Application by Steeple Solar Farm Limited for an order granting development consent for the Steeple Renewables Project

The Examining Authority's written questions and requests for information (ExQ2): Issued on 3 March 2026

## Appendix 2: Typical PV Module Rack Detail for Ballasted Foundations

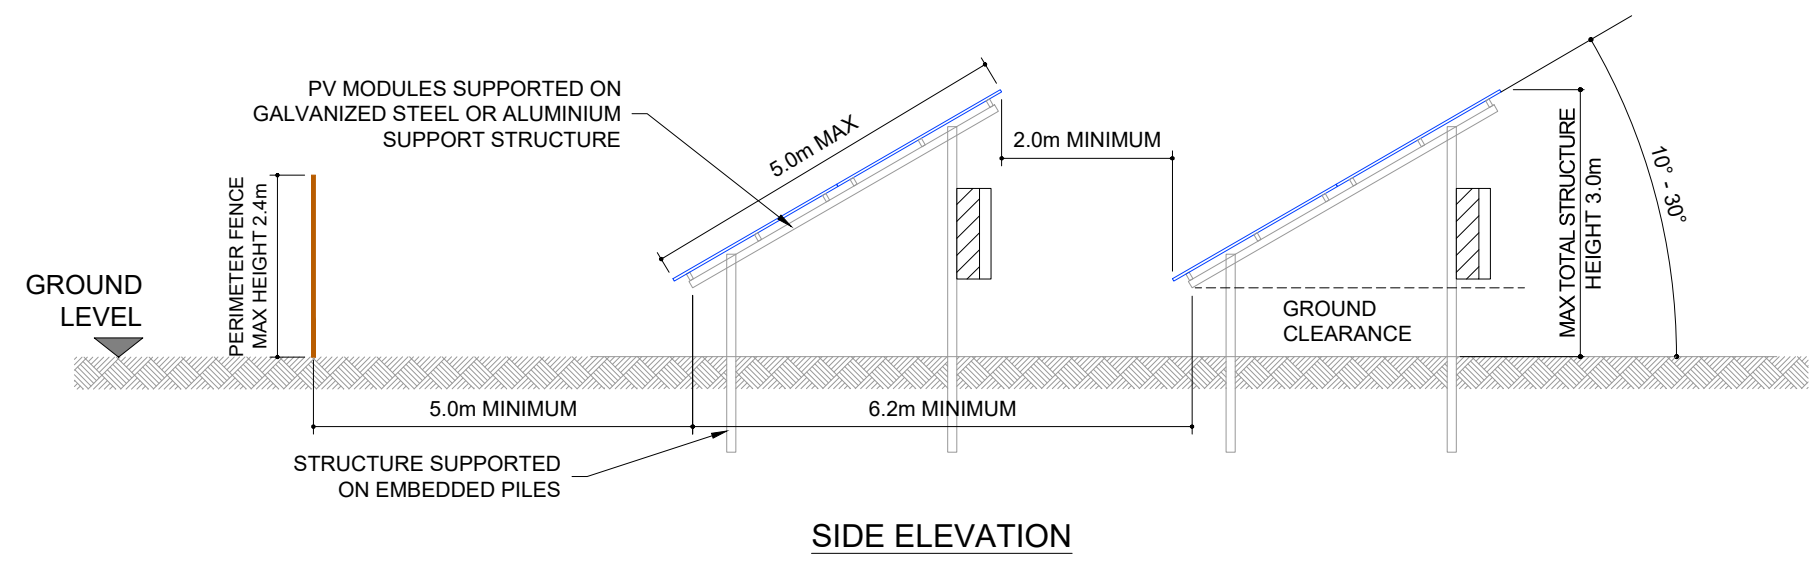
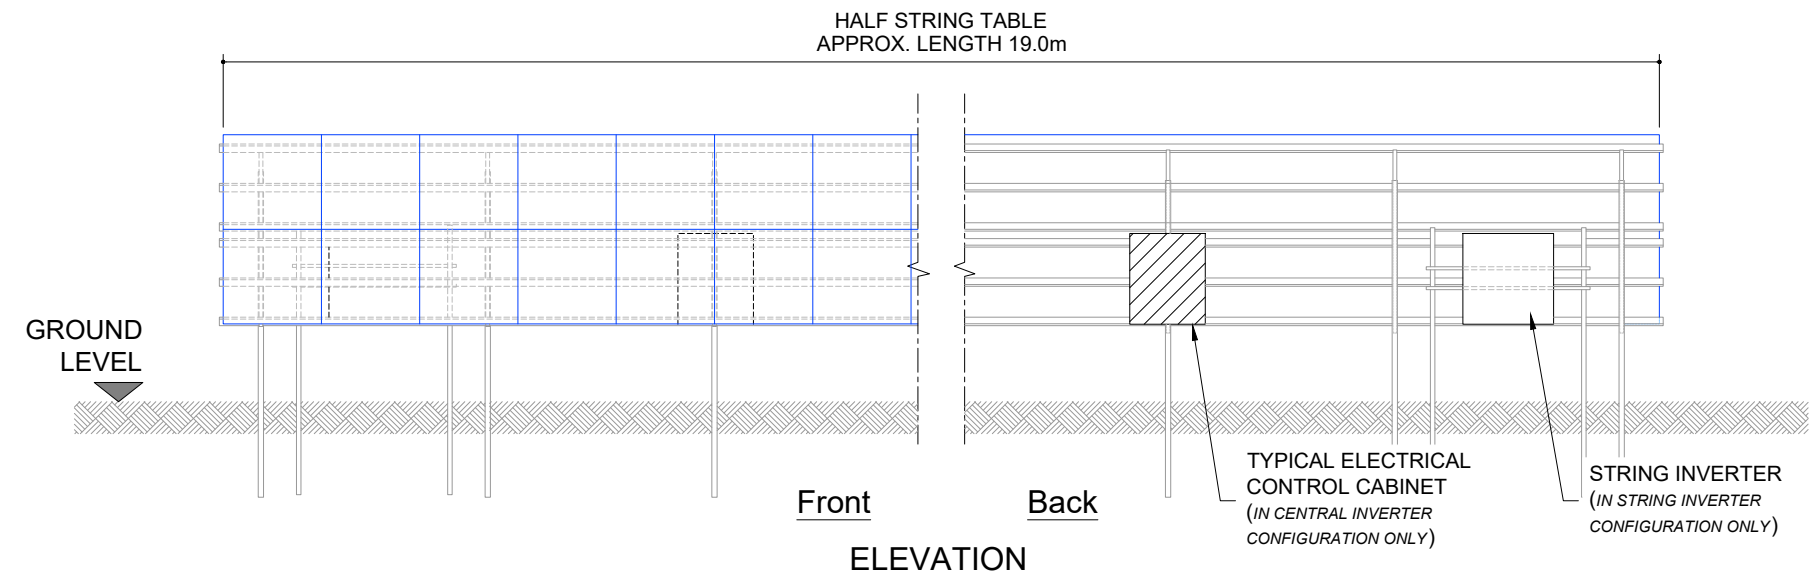
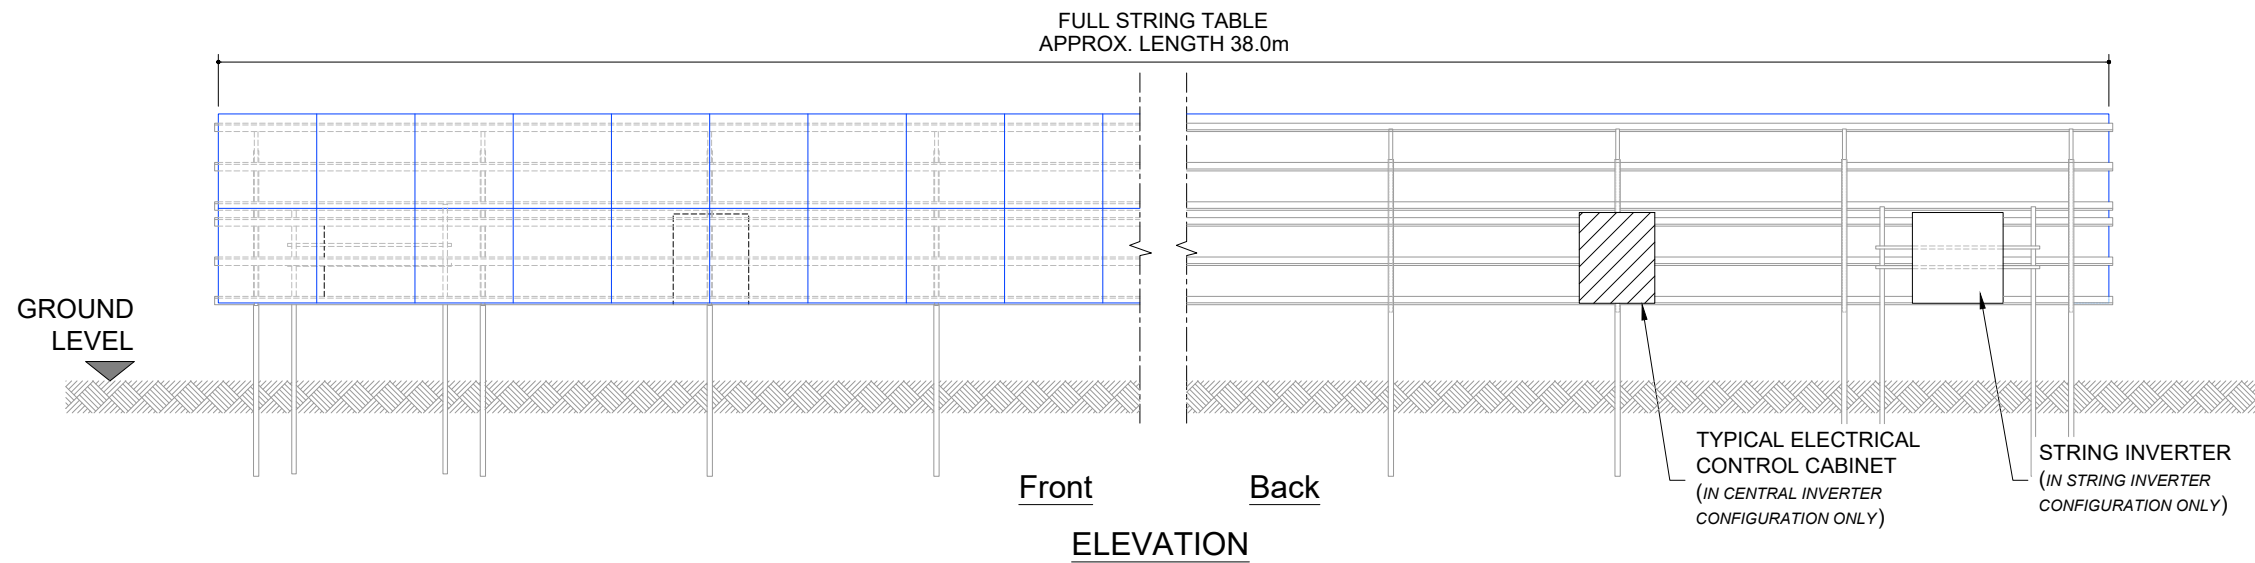
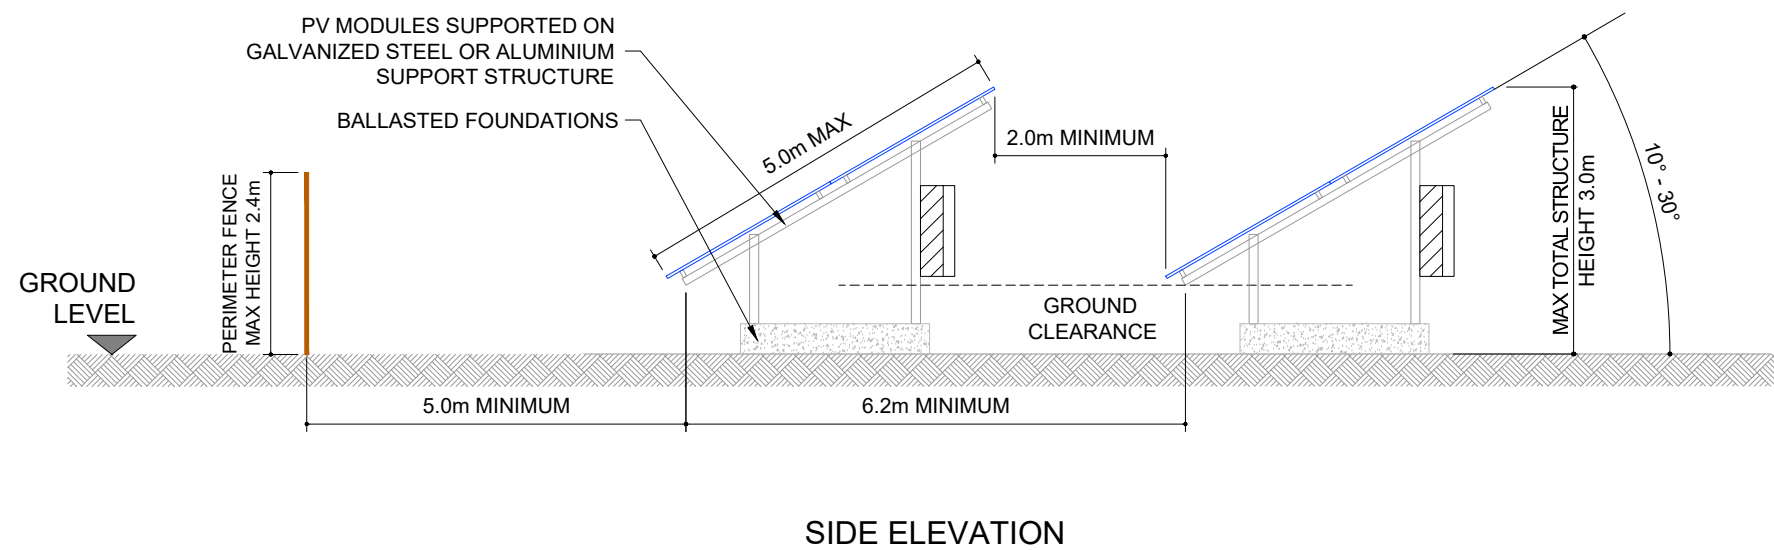
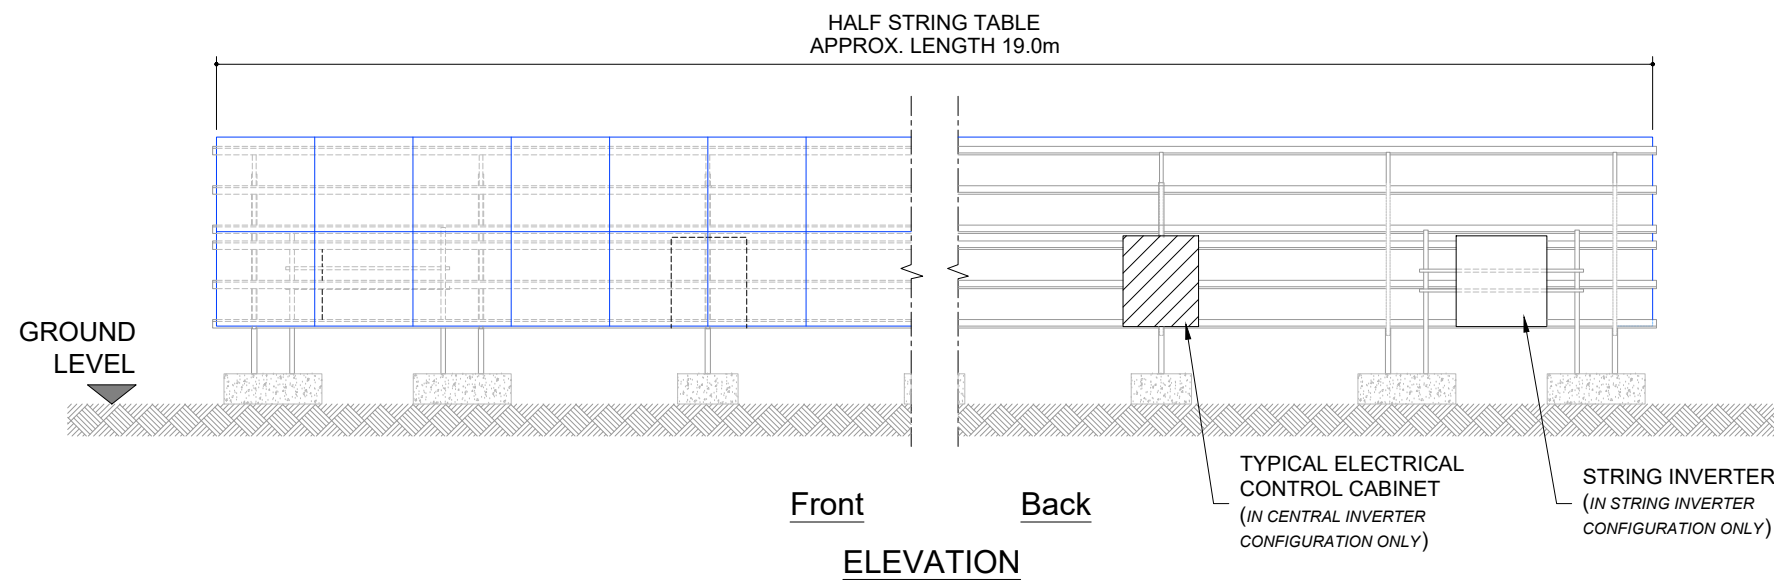
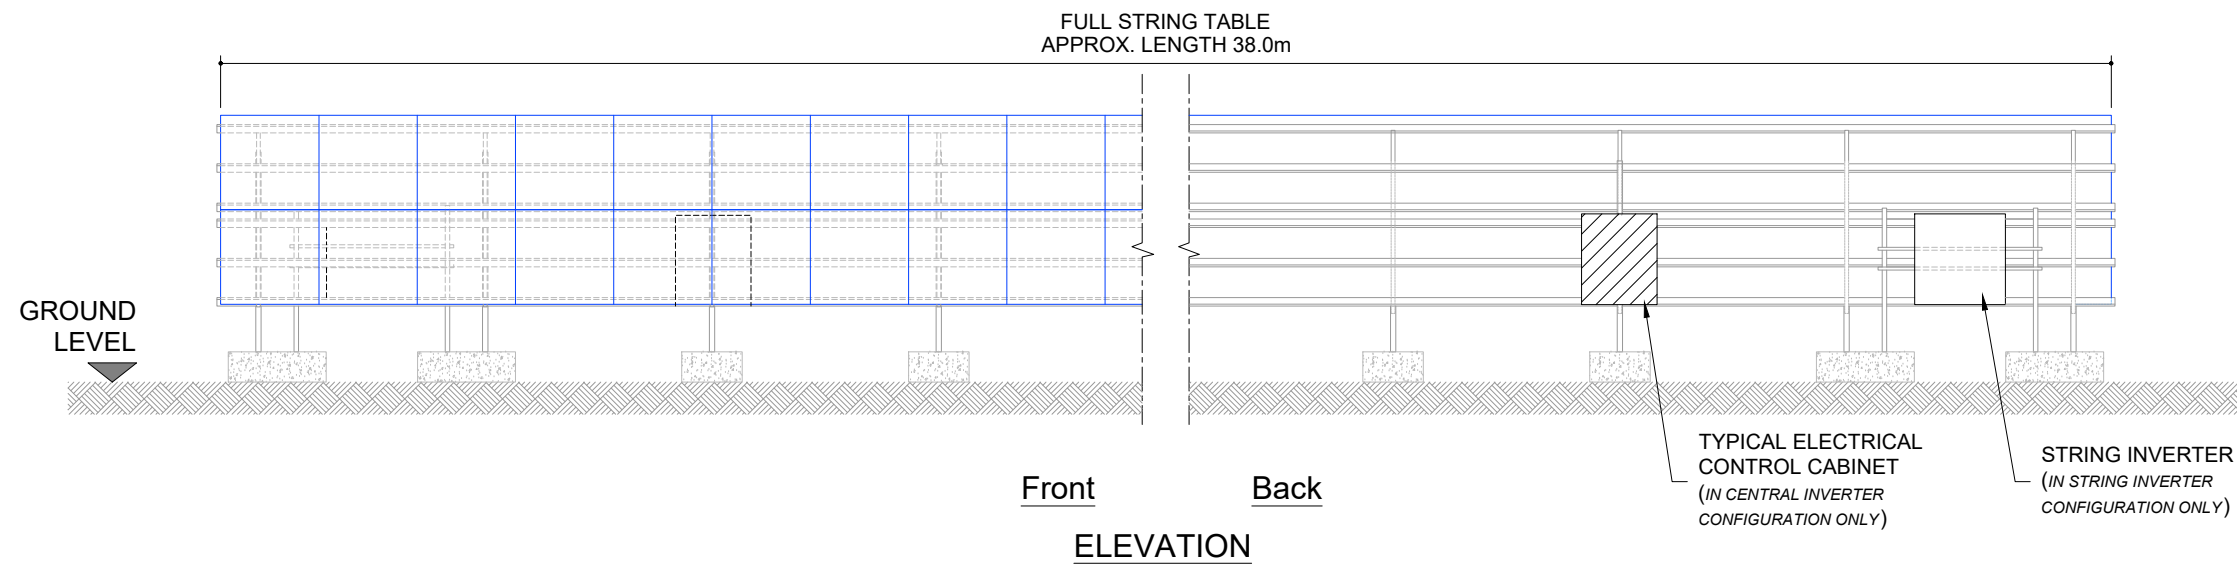
Q11.0.8	The applicant and NCC	<p>Use of ballasted foundations for preservation <i>in situ</i></p> <p>Paragraph 4.4.13 of ES chapter 4 [APP-062], ES Appendix 4.5 [APP-093] and section 9 of ES Appendix 9.5 [APP-126] refer to the use of ballast slab foundations where archaeology constraints have been identified and areas of 'no dig' construction. Provide further details explaining how the use of such foundations would preserve any archaeological sensitive areas or assets of archaeological significance in perpetuity, how these would be secured as part of the detailed design process and the extent to which such foundations could affect assets that are located at shallow depths.</p> <p>NCC is also asked to submit comments on the suitability of using ballast slab foundations in areas of high archaeological significance and the potential effects to assets.</p>
Q11.0.9	The applicant	<p>Christian Heritage and the Pilgrim Trail</p> <p>Comments were submitted by Sturton le Steeple Parish Council at deadline 4 [REP4-037] providing further submissions to explain 'How the Christian Heritage contributes to the significance of the heritage assets in the area in our opinion'. Please respond to the points made.</p>
